**Newcastle Power Station (SSI-9837)
Submissions Report**

Attachment 1

The preliminary hazards assessment (PHA) included in the Environmental Impact Statement (EIS) of the Newcastle Power Station Project must demonstrate that the risks from the project can comply with the criteria set out in the Department's *Hazardous Industry Planning Advisory Paper No. 4 Risk Criteria for Land Use Safety Planning* (HIPAP 4).

Figure 3 : Overall Proposal Layout Plan and tie-in to existing utilities

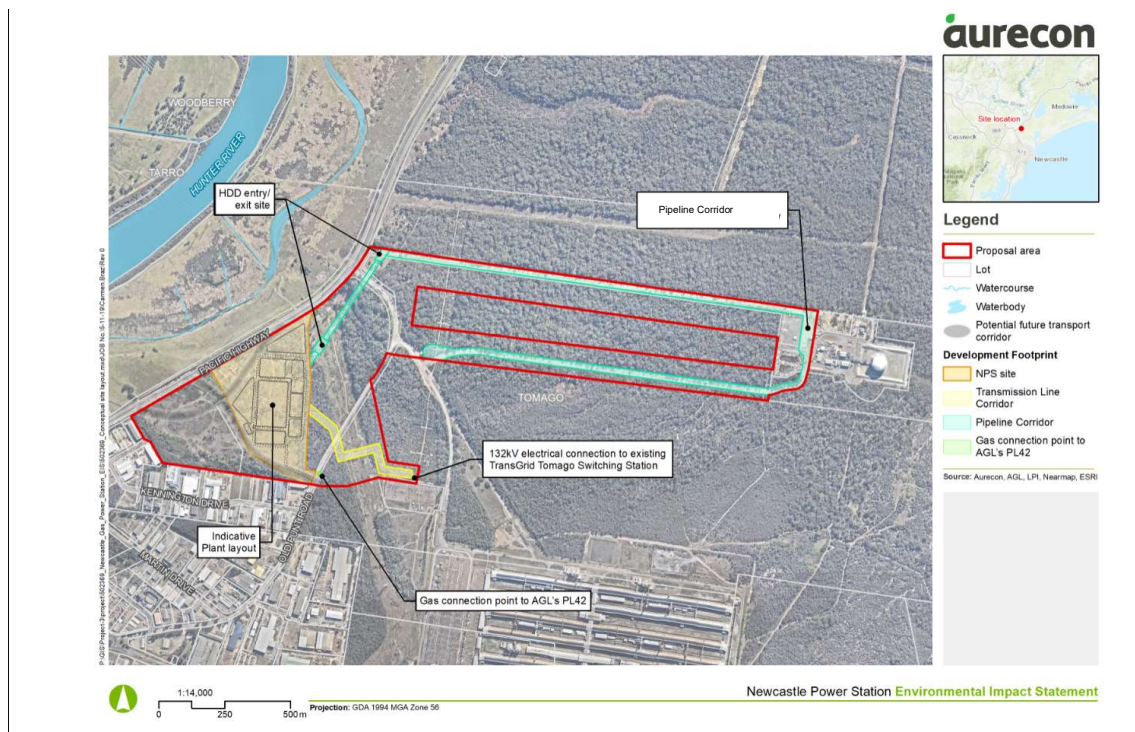
- clarification on whether a Vessel Phast Model has been adopted and whether a linear source risk model should be adopted;
- site layout diagrams to include more detail pertaining to proposed pipelines, pigging stations, compression stations (reciprocating compressors), tie in pipelines at the dual fuel peaking power plant (NPS), aboveground connection from Horizontal Directional Drilling to NPS and clearer connection points/lines at AGL's Newcastle Gas Storage Facility, separation of gas generator housing to control room and switchyard, etc;

Figure 8: Individual Fatality Risk Contours Site and Pipelines

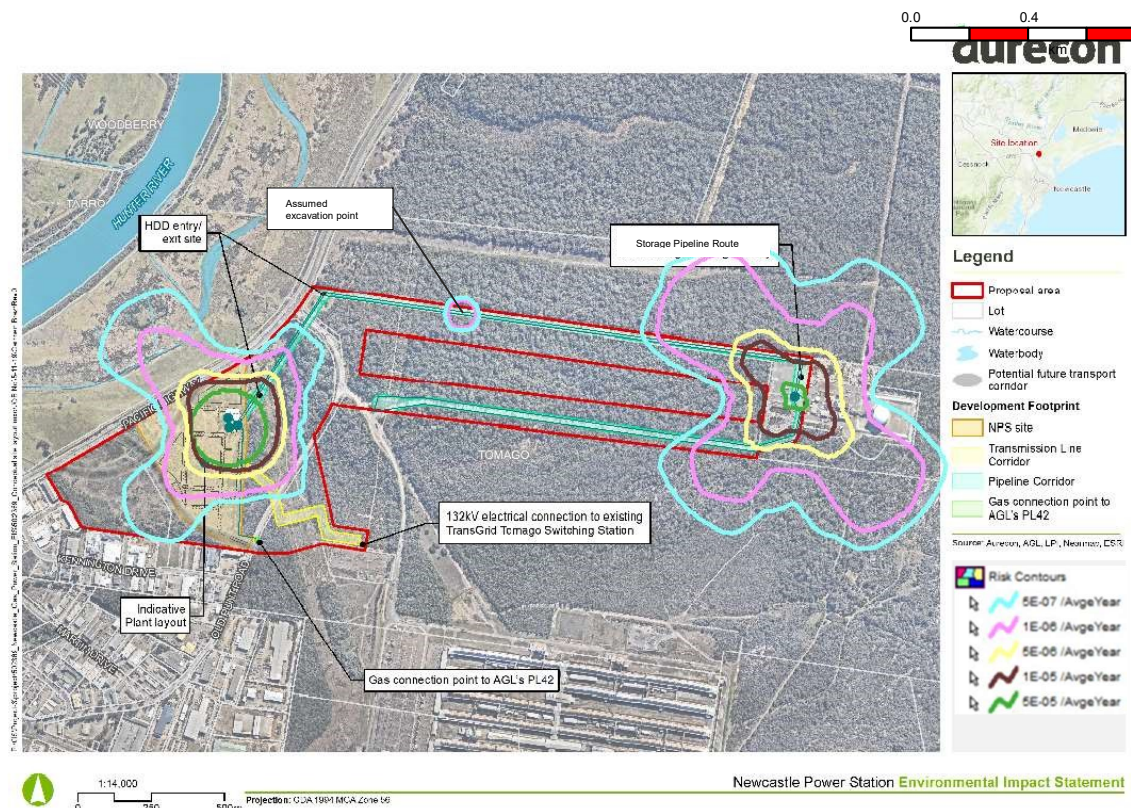
- the individual fatality risk and illustrate the Individual Risk (IR) contour shown in Section 10.3 of the PHA. It should clearly illustrate the potential interaction between the IR risk contour to the neighbouring facility (circular vs contour along the pipelines); and
